**Consultation Response from KC,  
Trees**

**2023/92712 Land adjacent, 36 Oxford Road, Dewsbury, WF13 4LL**

**Erection of 40 bed care home and 12 independent supported living units (use class C2) with associated works including the formation of car park and service access**

**Date Responded: 09/04/2024**

Proposed Site Plan

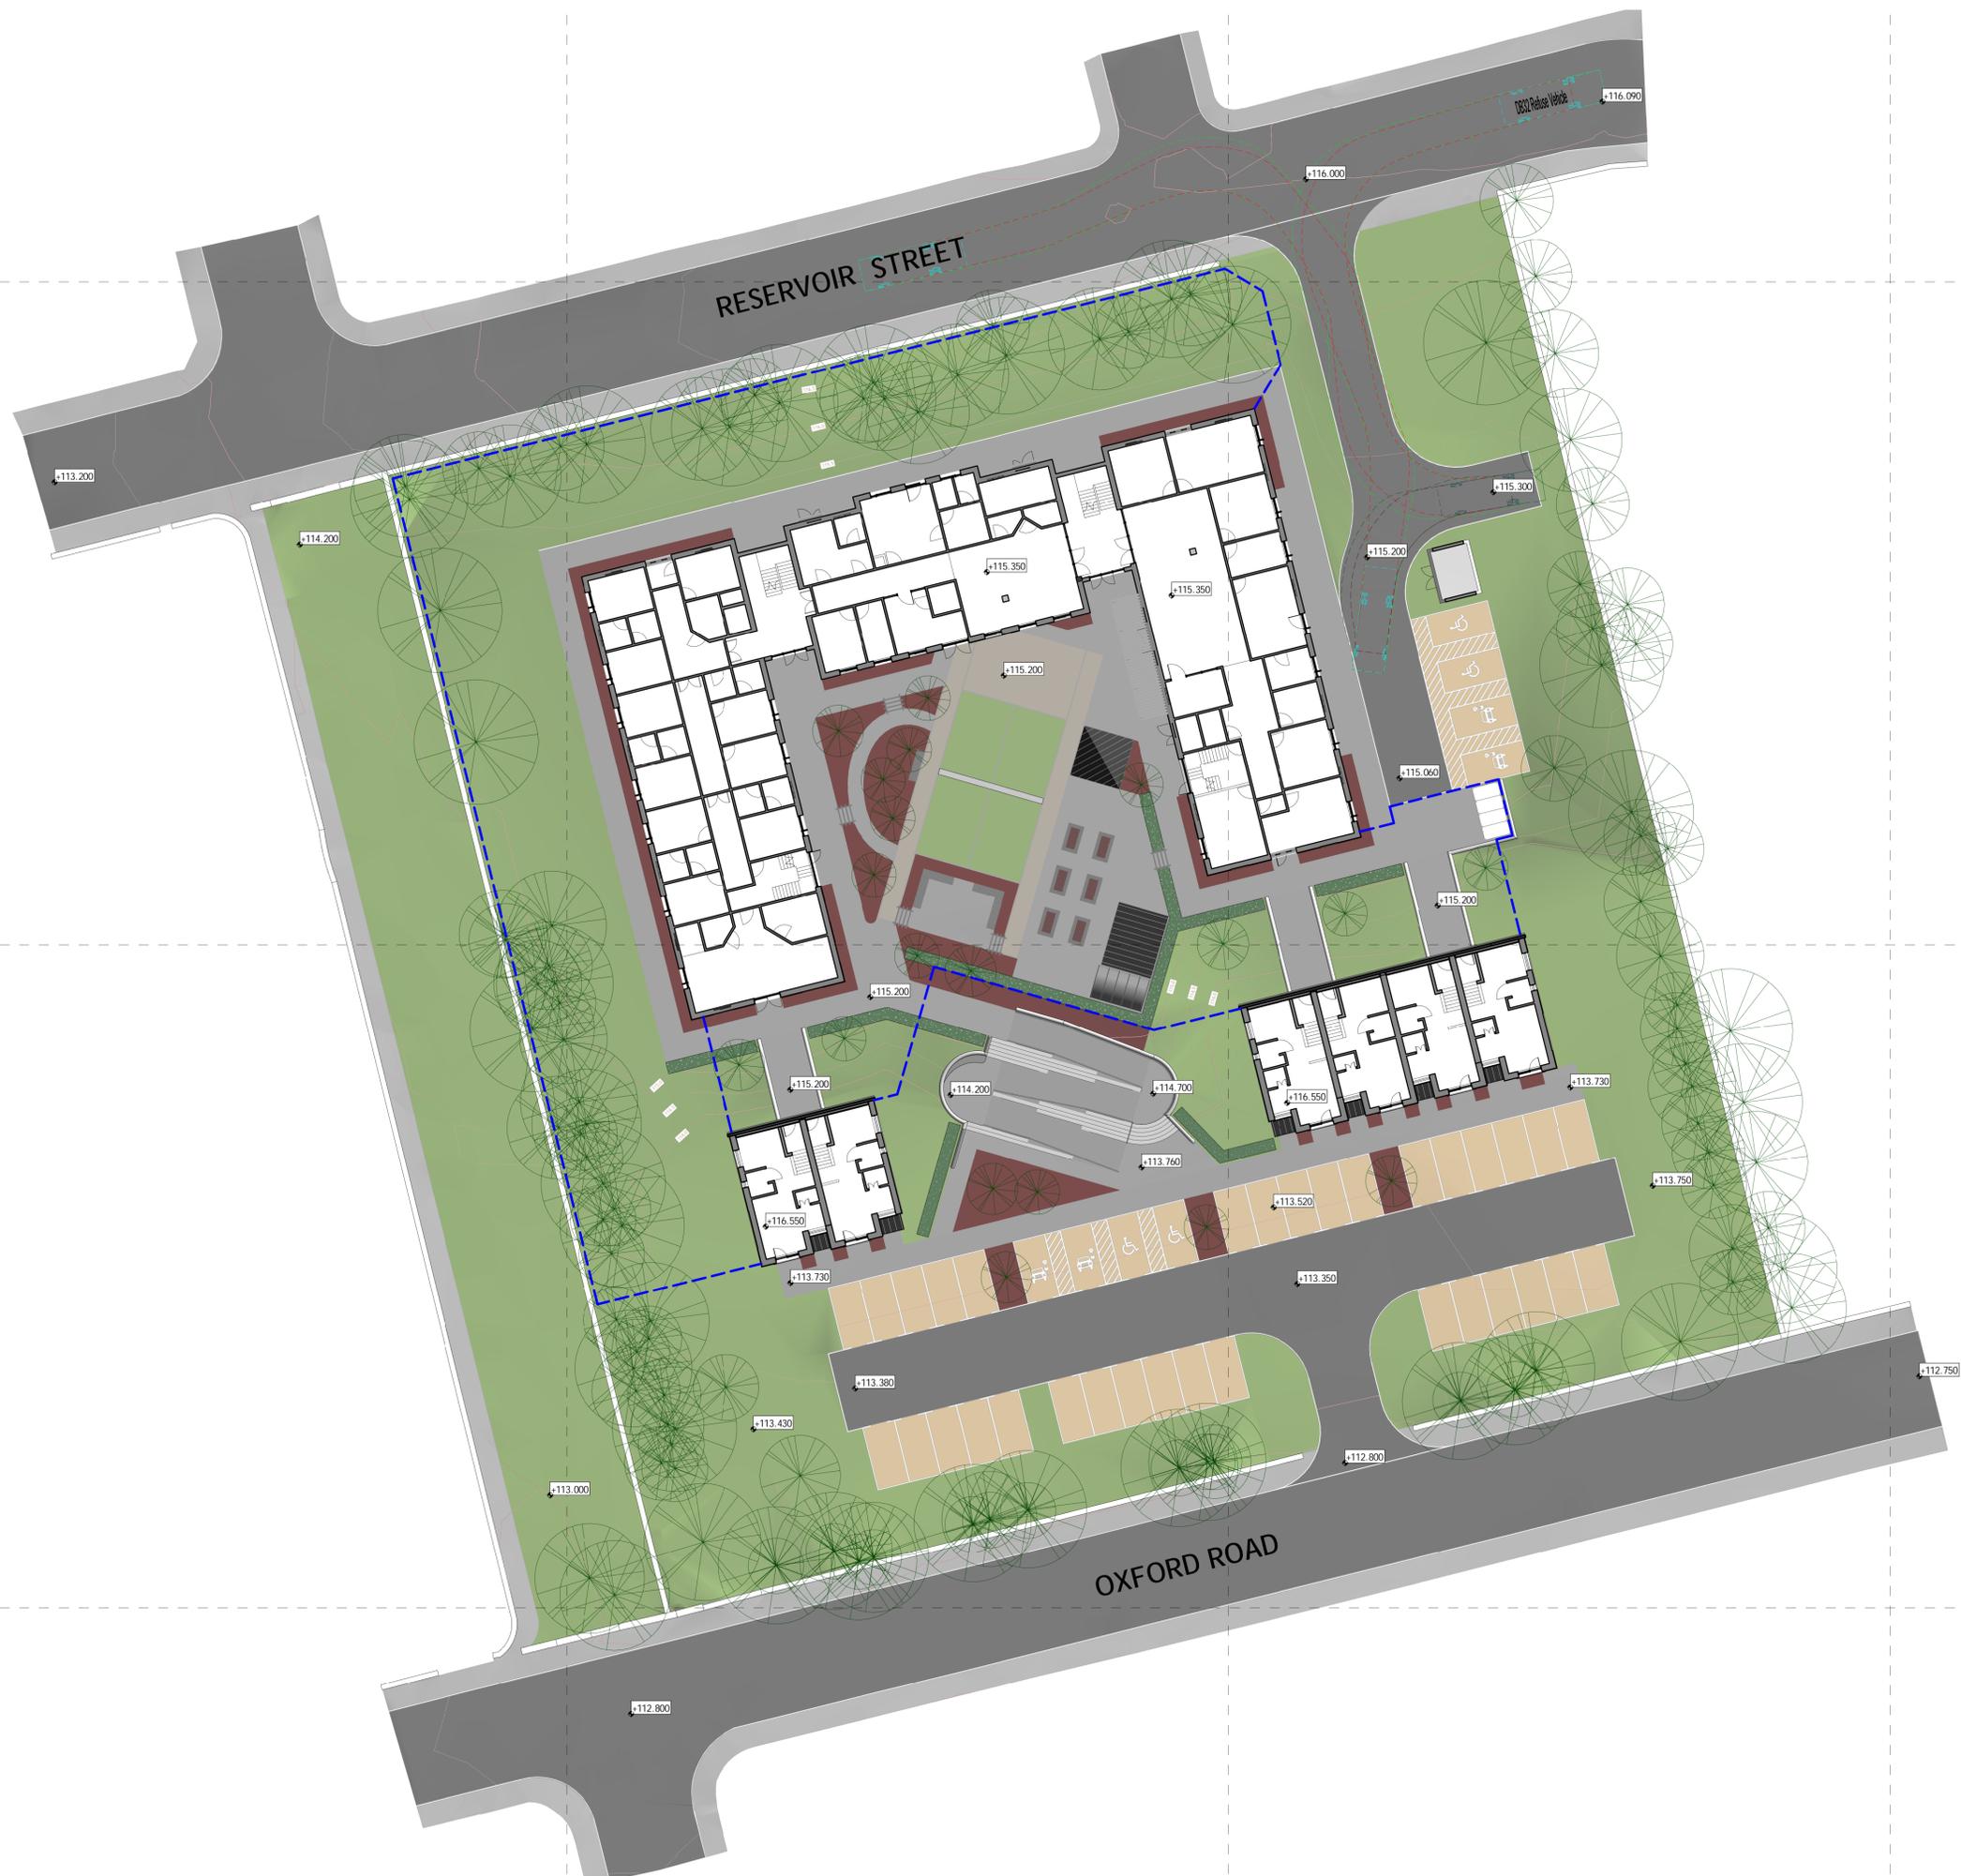
- Pile and beam foundation are preferred within footprint of western elevation of unit within the RPA of T26, T27, T28 and T29.
- Specific details on how the footpath within the RPA's of retained trees T26, T27, T28 and T29 will be construction.

A geo textile "no dig" construction method is required.

Below Ground Drainage Layout and Details

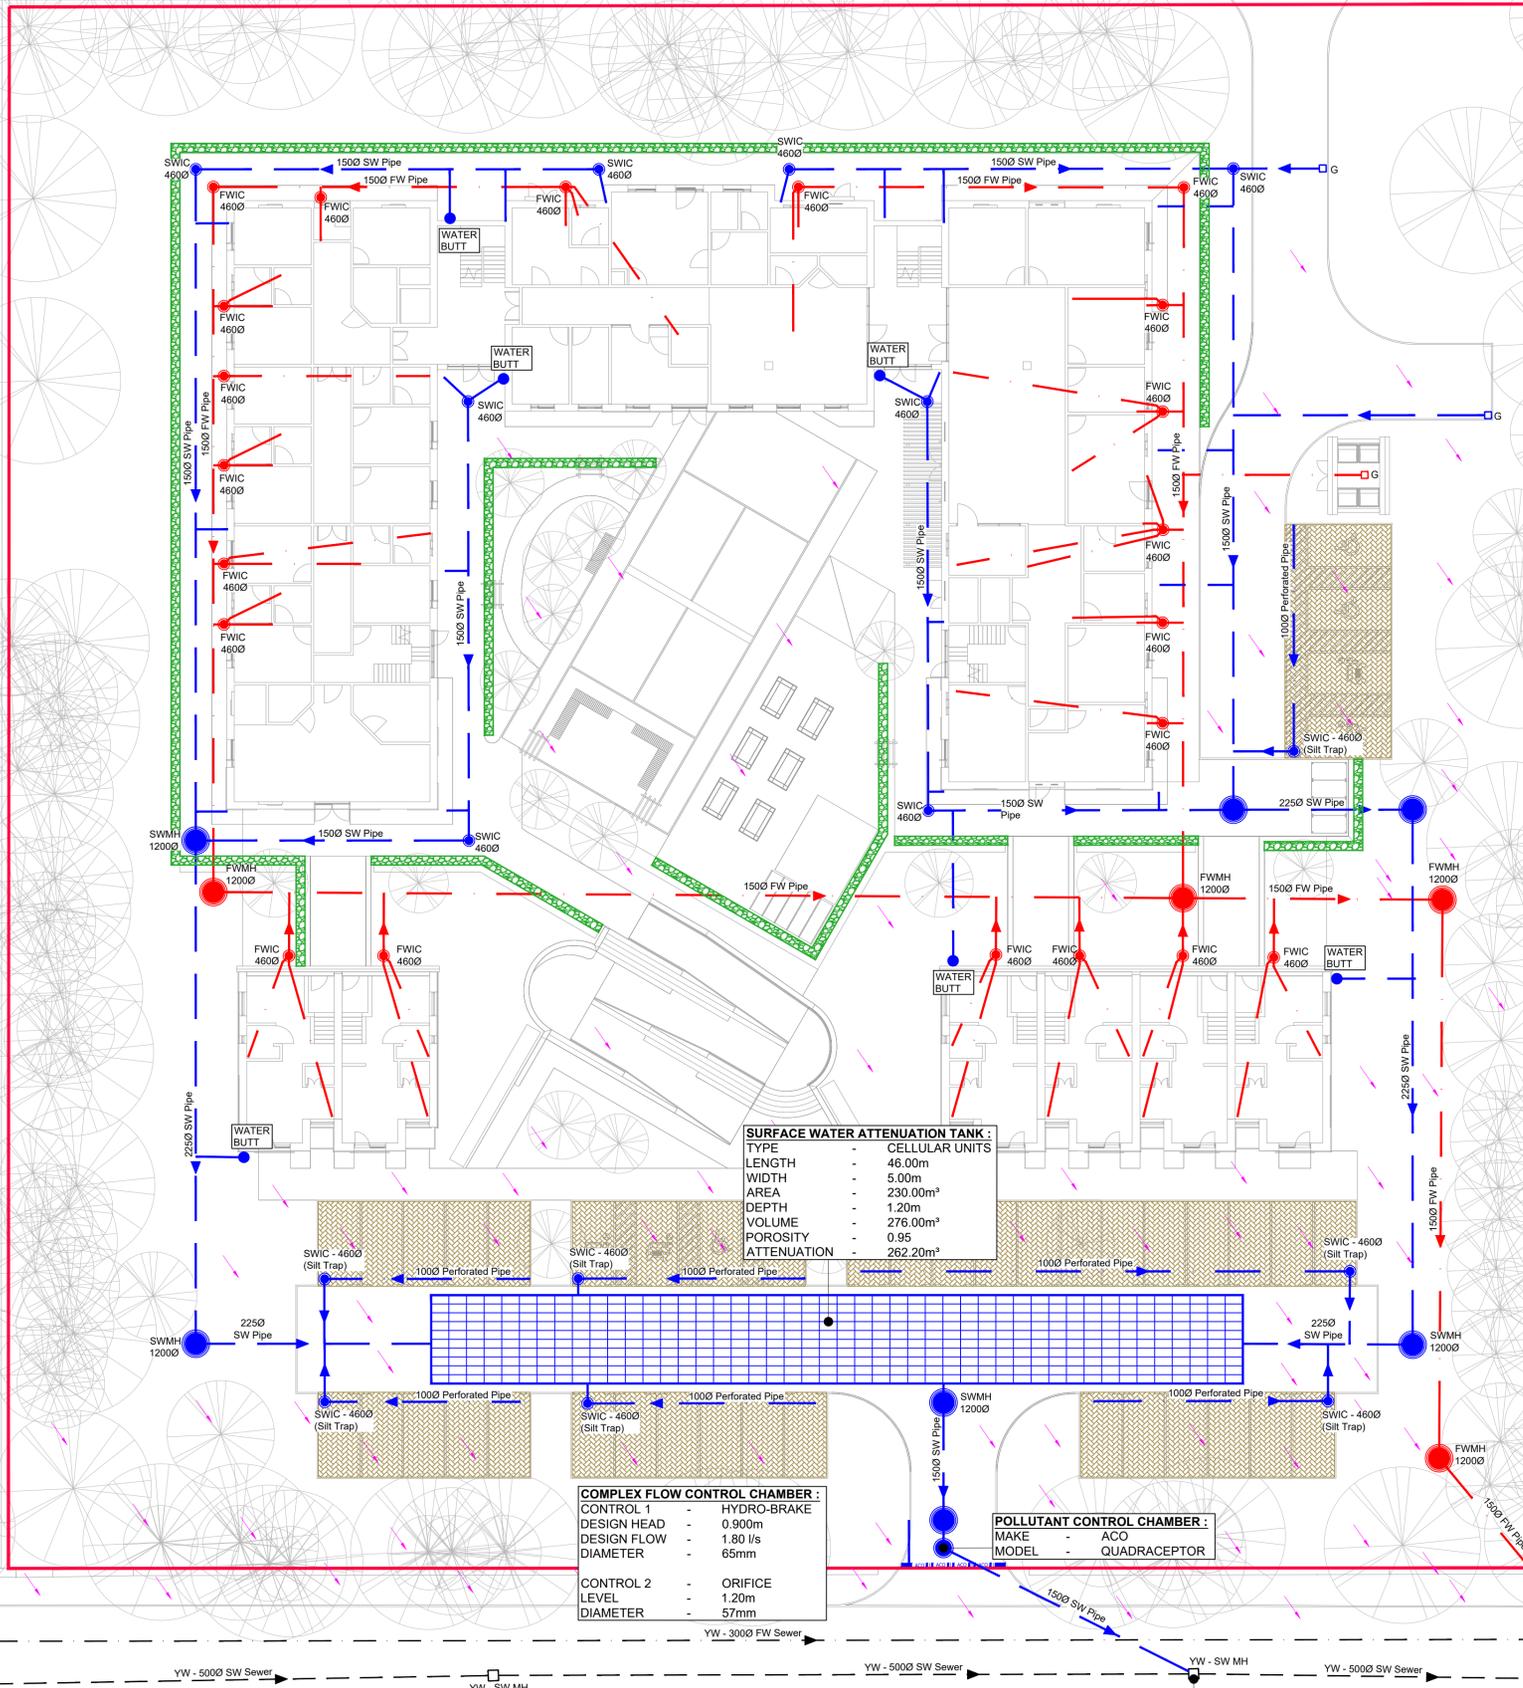
The surface water management report Rev B appears to be proposing runs crossing the RPA of retained trees. Which isn't ideal. Is there any scope to alter the route and keep them out of the RPAs of T26, T27, T28 & T29? Further detail is needed and could be conditioned if needed:
